Our Ref: EN010149

Application by Springwell Energy farm Limited for an Order Granting Development Consent for the Springwell Solar Farm (EN010149)

Advice following issue of decision to accept the application for examination

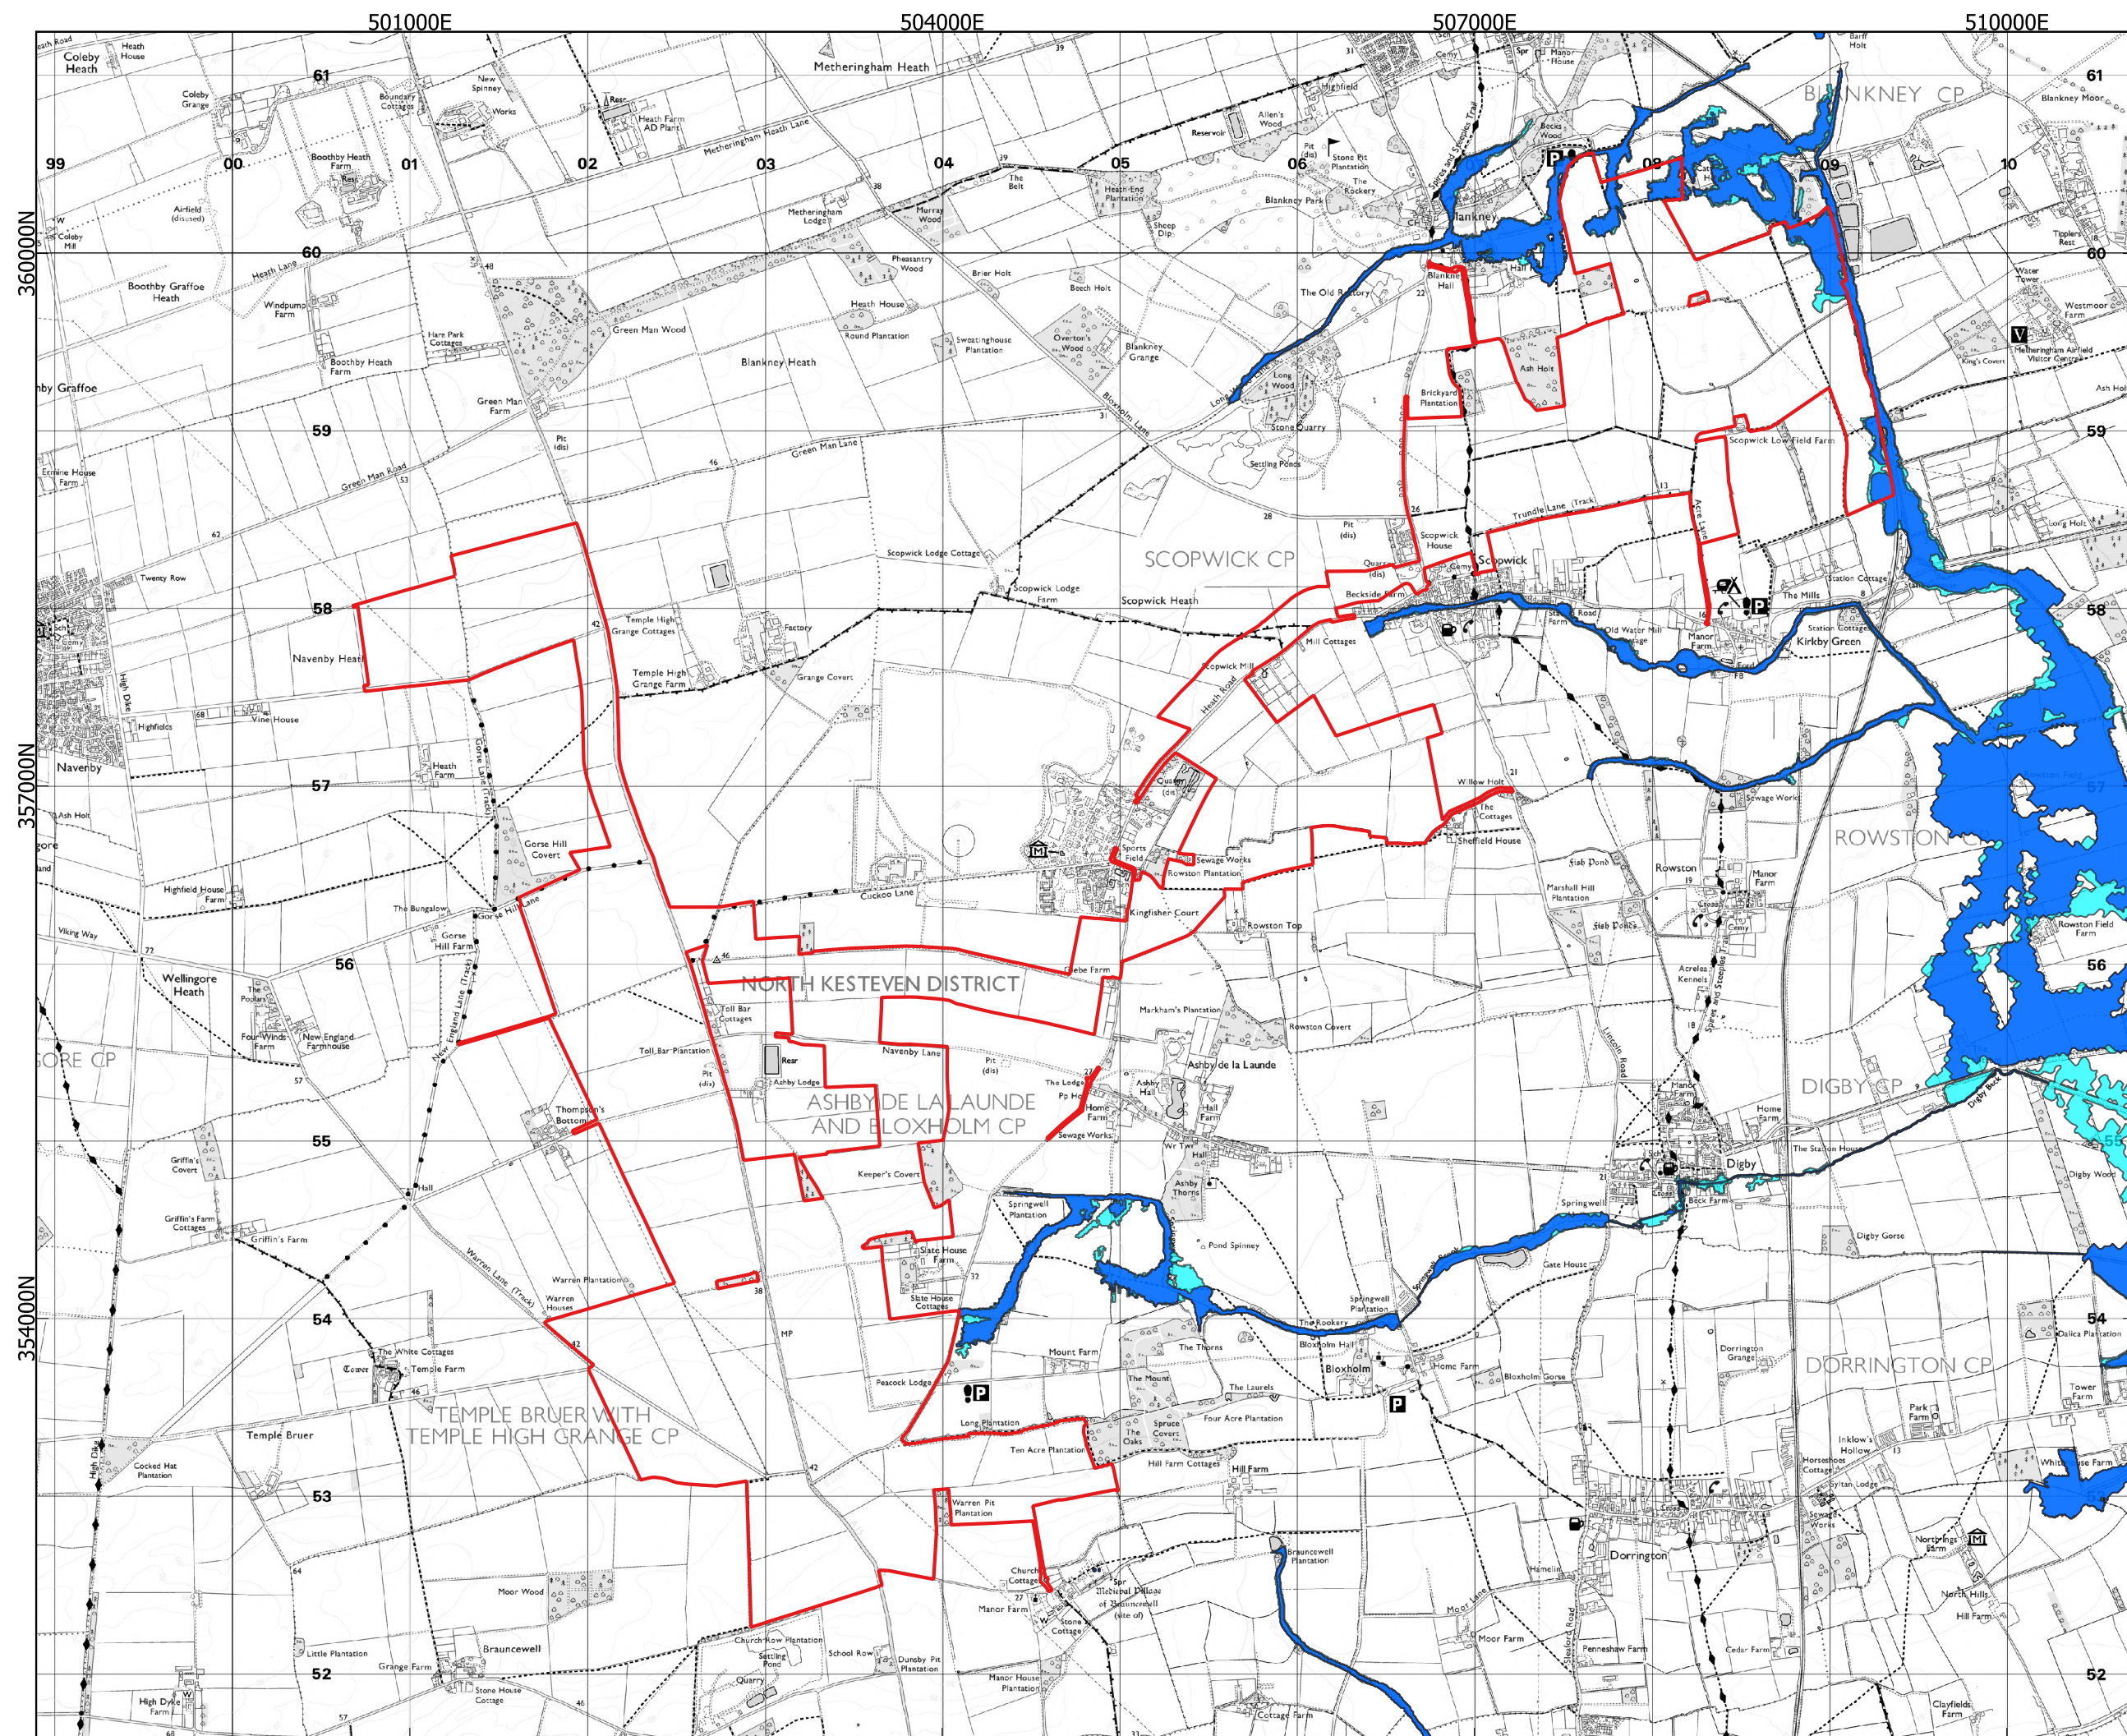
The Flood Risk Assessment (FRA) (Document Reference 7.16) describes that the Proposed Development is primarily located in Flood Zone 1, with a small region within the northeastern corner of the site located in Flood Zones 2 and 3. The FRA does not specify whether the components located within Flood Zone 3 are within Flood Zone 3a or Flood Zone 3b or a combination. Flood Zone 3a and Flood Zone 3b are not differentiated on the figures in the FRA. An updated FRA with plans differentiating Flood Zone 3a and 3b should be reissued.
